Re: Formal Objection – Cooloo Wind Farm Application and EIAR (2025) - 323761

Technical Review Report – Chapter 8: Land, Soils & Geology (Cooloo Wind Farm EIAR)

TYPE A - TYPICAL ROAD SIDE SETTLEMENT POND DETAIL
SCALE 1:100 (NOTE DIMENSIONS VARY DEPENDING ON CATCHMENT SIZE - SEE ATTACHED TABLE)

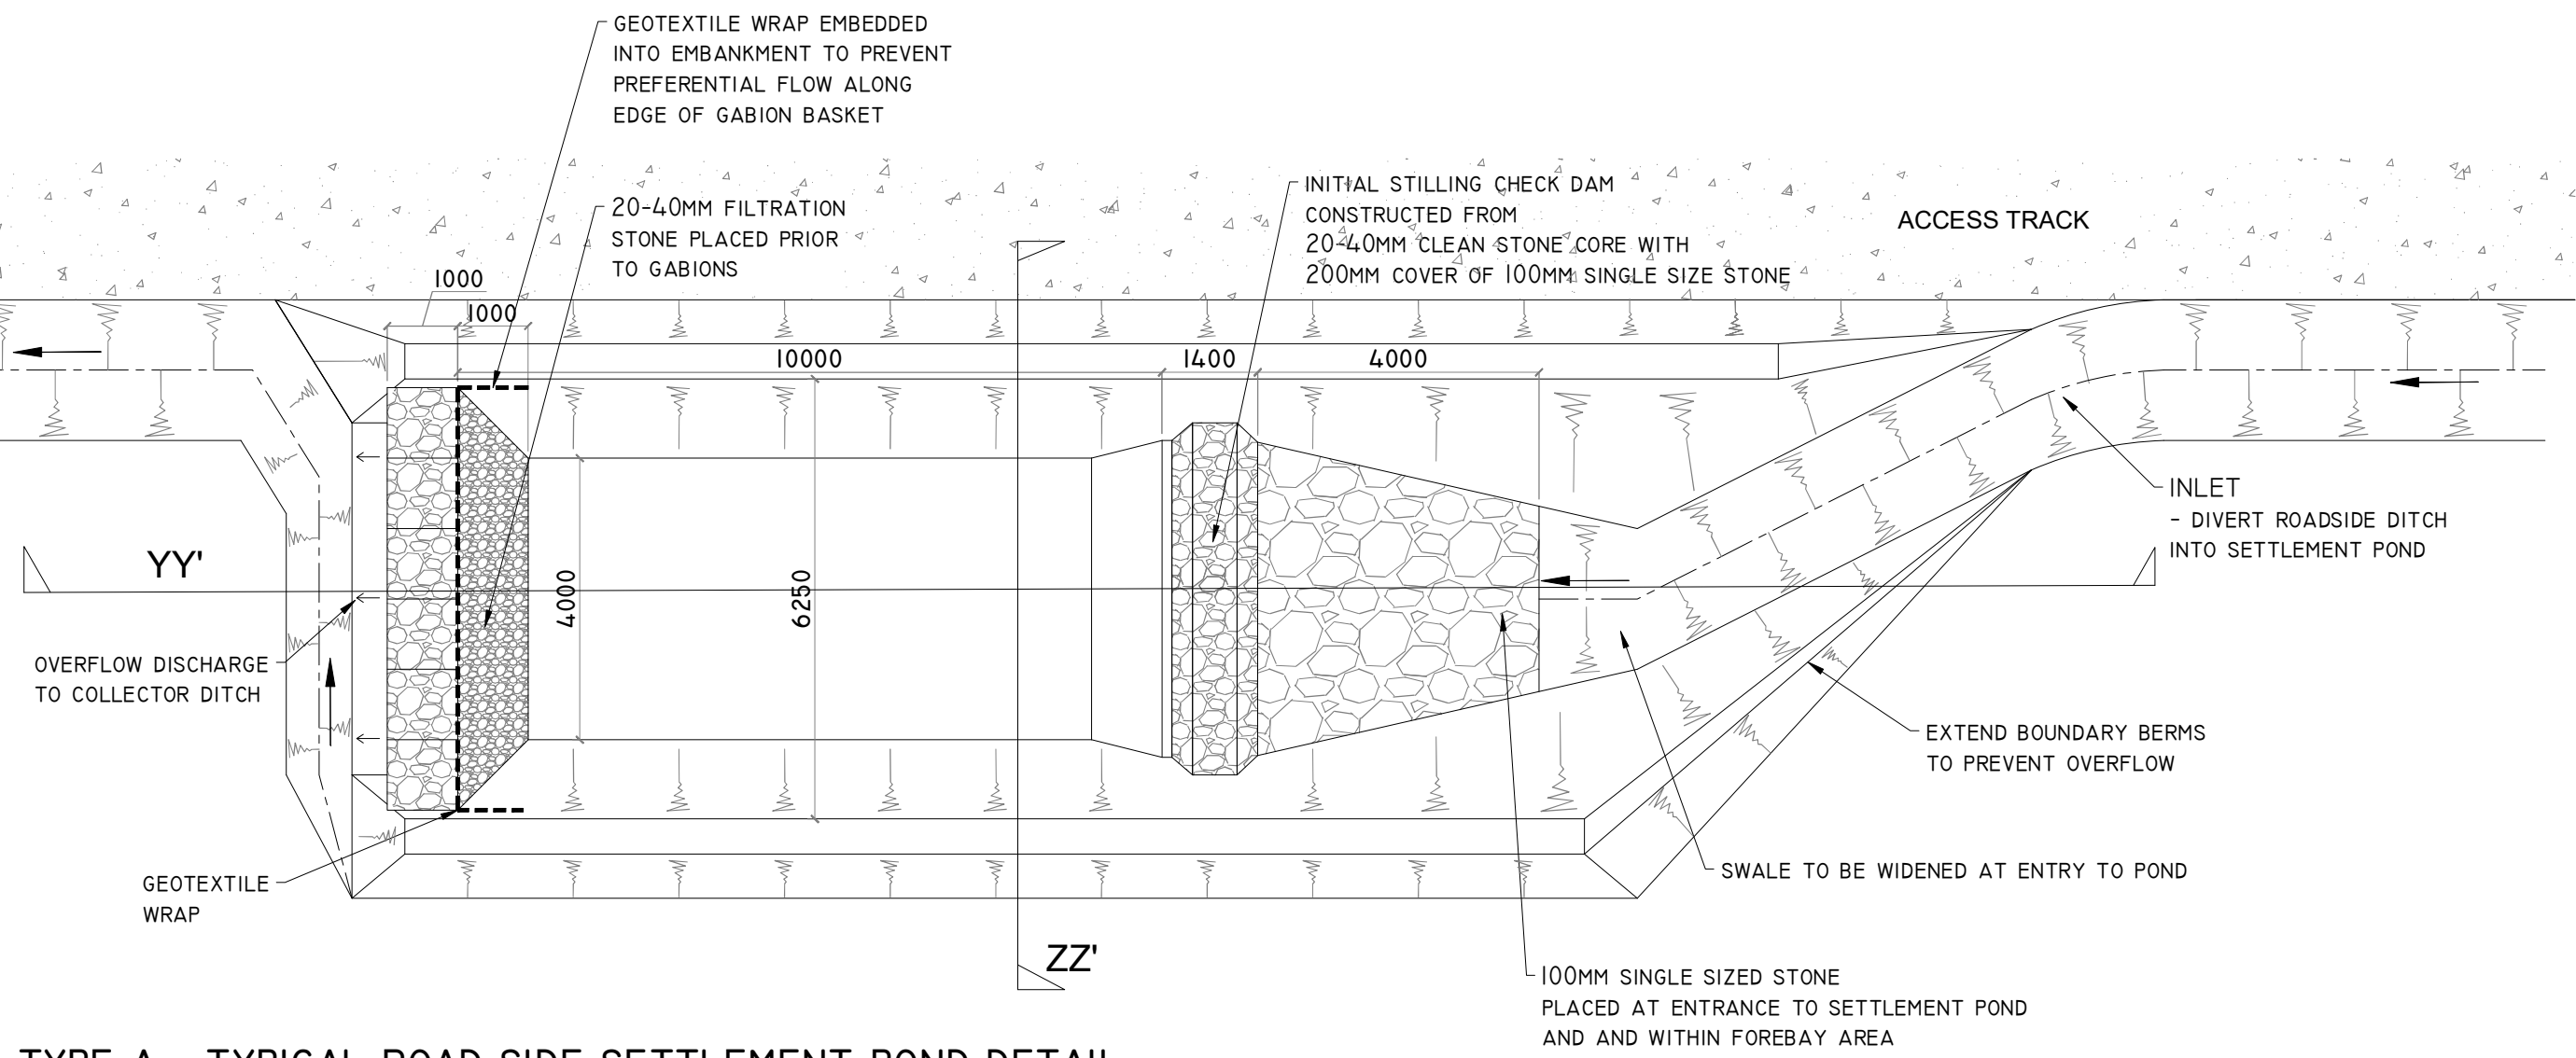
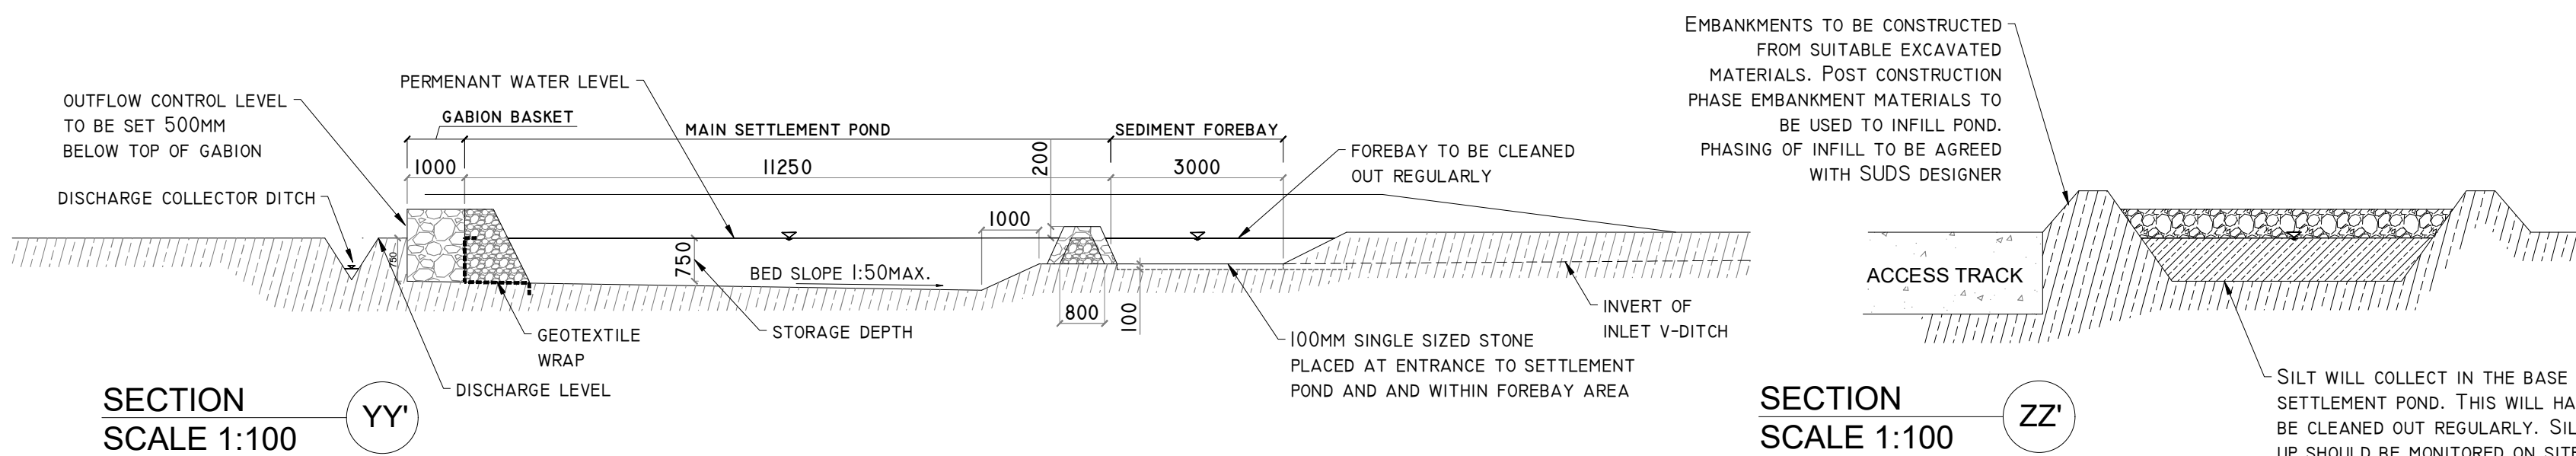
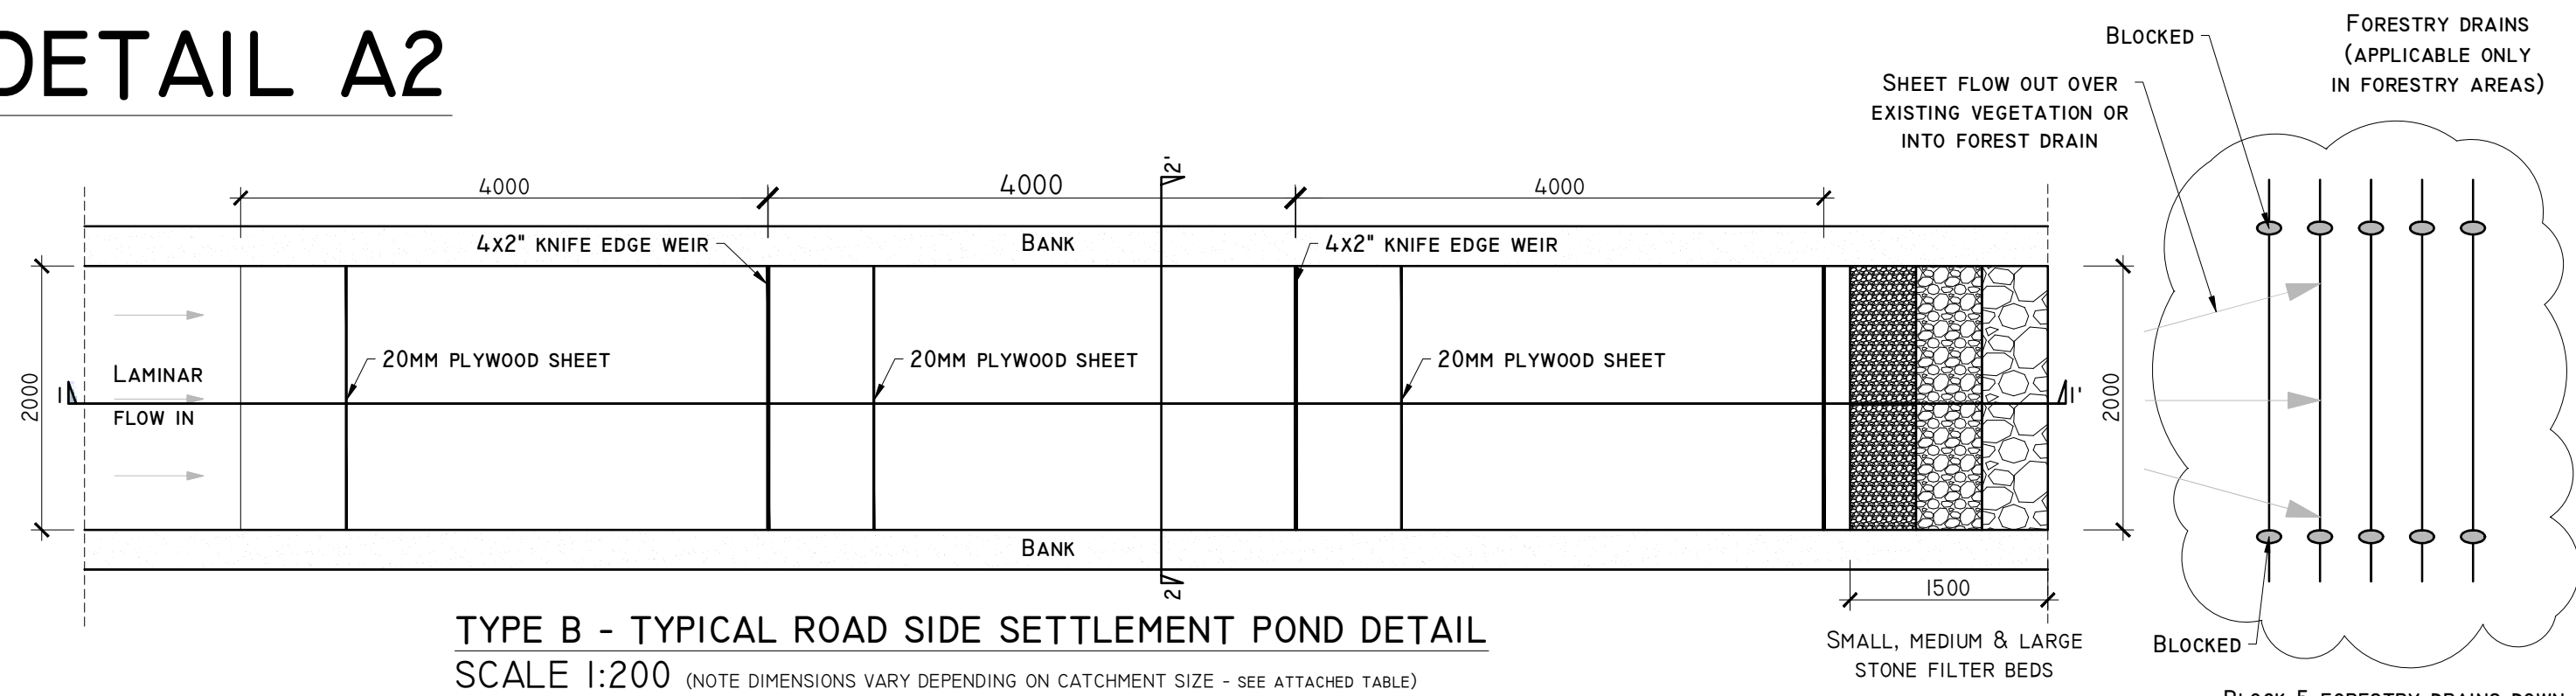
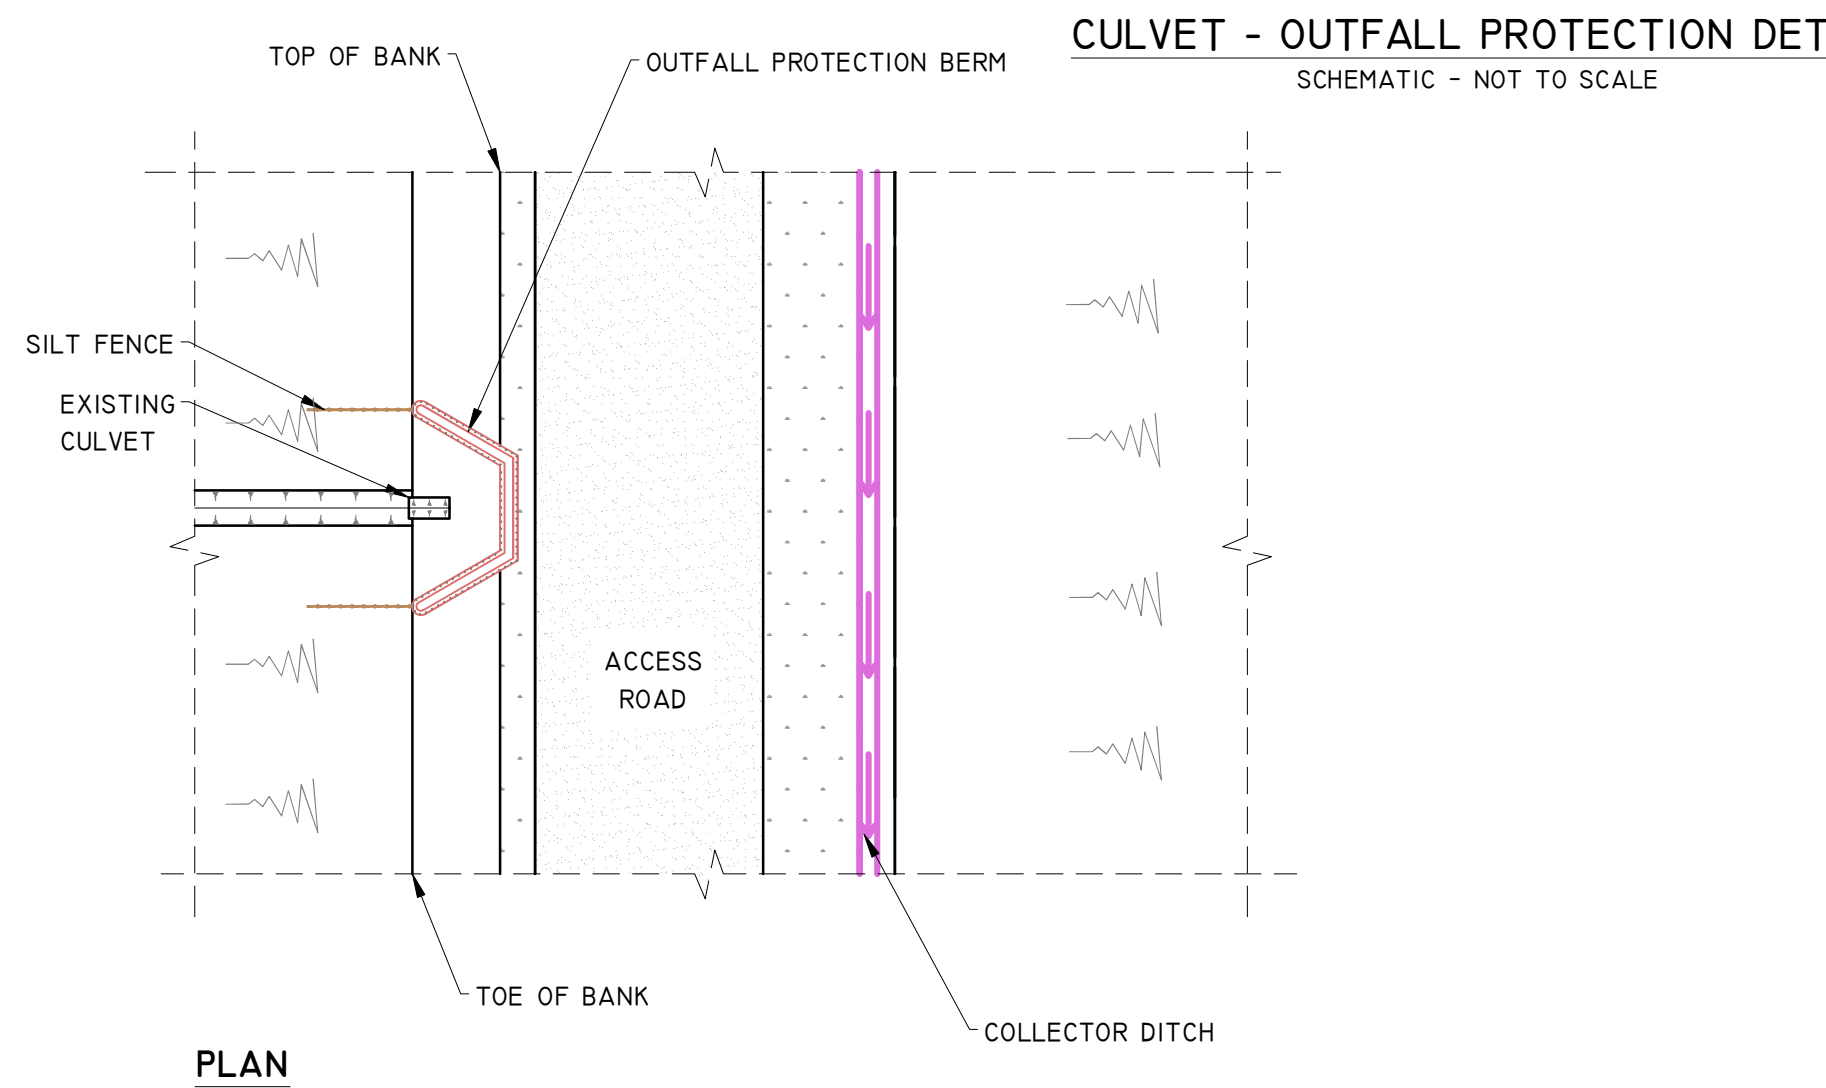
Drainage designed for a 10-year storm event with generic sediment controls. No climate-change factor or cumulative runoff modelling. Discharges drain to River Clare → Lough Corrib SAC.

Figure 8-3 Summary Peat Depth Map

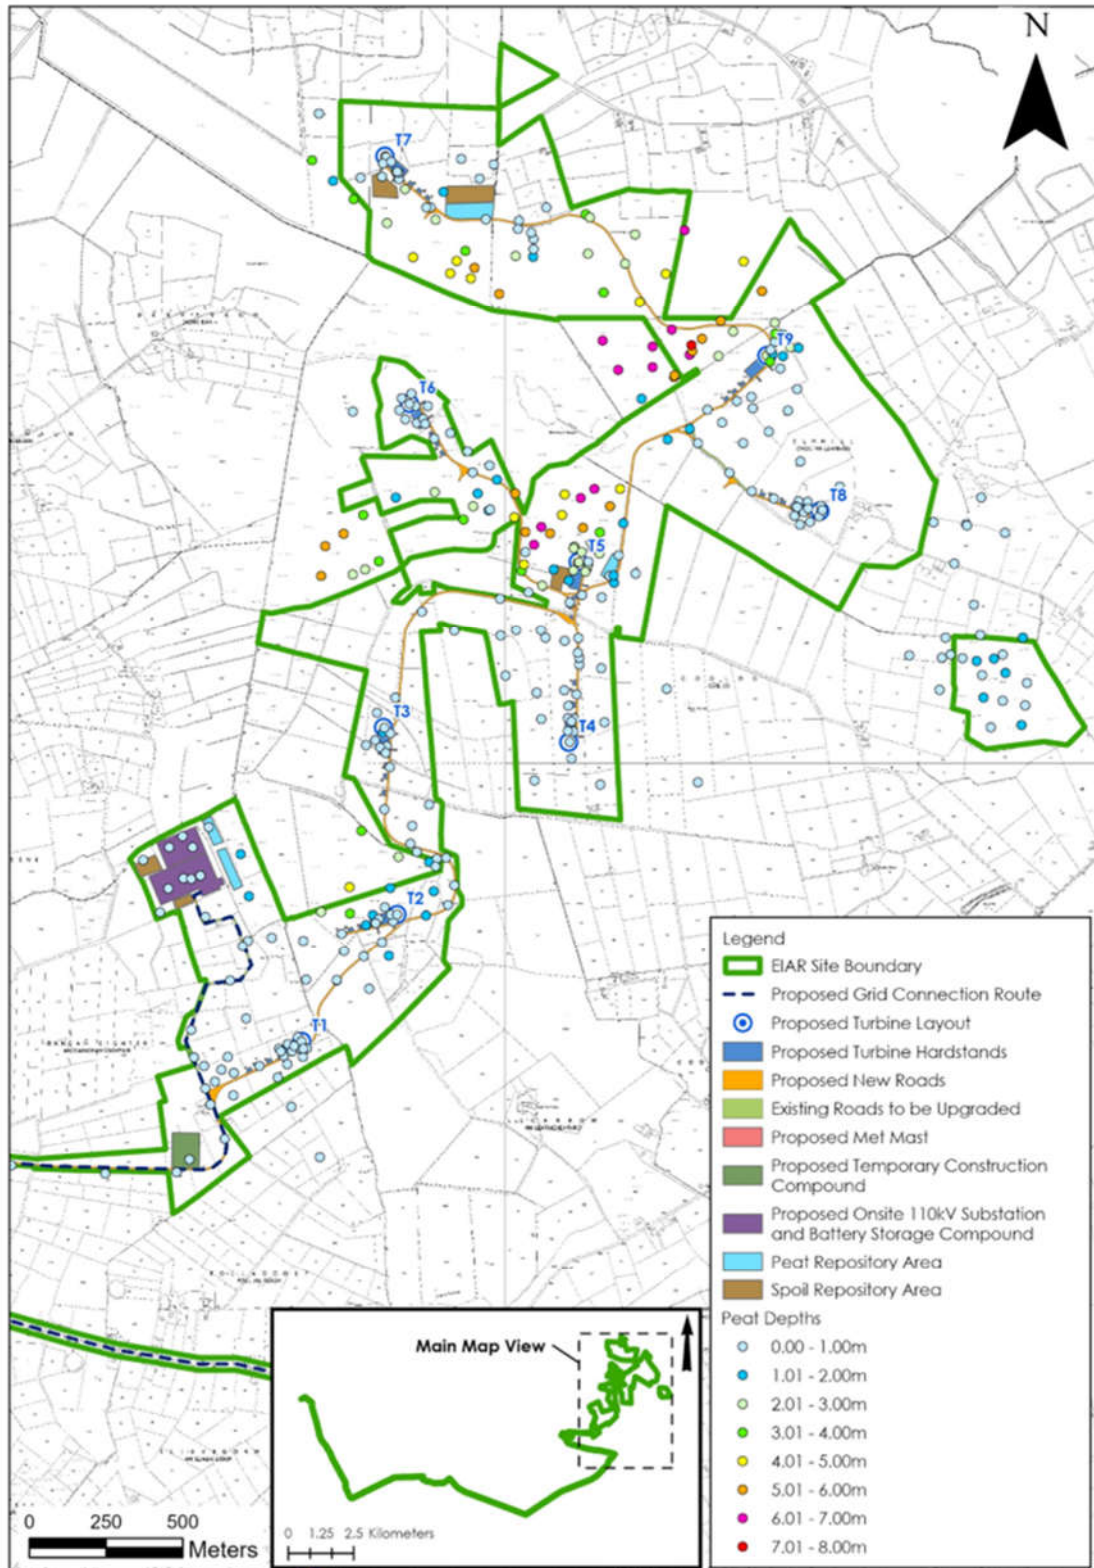
- Reliance on only two boreholes and 306 shallow probes across 9 turbines is insufficient for slope stability confidence.
- No quantitative slope-stability modelling for worst-case conditions; repeats errors of *Derrybrien (ECJ C-215/06)*.
- Peat and Spoil Management Plan defers design details to post-consent stage.
- Karst risk underassessed – limited geophysical coverage (~500 m) despite 41 mapped features.

Issue	Critique / Objection	Comment
<p>Survey sufficiency: spatial & depth coverage</p>	<p>While 306 peat probes, 26 trial pits, and 2 boreholes are used, that may still be insufficient sampling density in areas of high risk (deep peat, slope transitions). The boreholes are only two — that is low for a project of this scale.</p>	<p>“The Chapter 8 investigation relies on only two boreholes for deep subsurface stratigraphy in a 9-turbine site, which is inadequate given the varying peat depths and subsurface complexity. The sampling density is insufficient in key areas (e.g. near turbine bases, along access roads crossing bog) to establish confidence in peat / geotechnical stability.”</p>
<p>Uninvestigated peat under grid route</p>	<p>They state that along the public road section of the grid cable route, peat was <i>not</i> investigated. This is a gap: the grid connection passes over areas where peat is possible, but they did not test it.</p>	<p>“It is unacceptable that no peat probing or subsoil investigations were carried out for the public road portion of the grid route. The assumption of no peat there is unverified, and risk of unexpected peat / soft ground conditions must be ruled out.”</p>
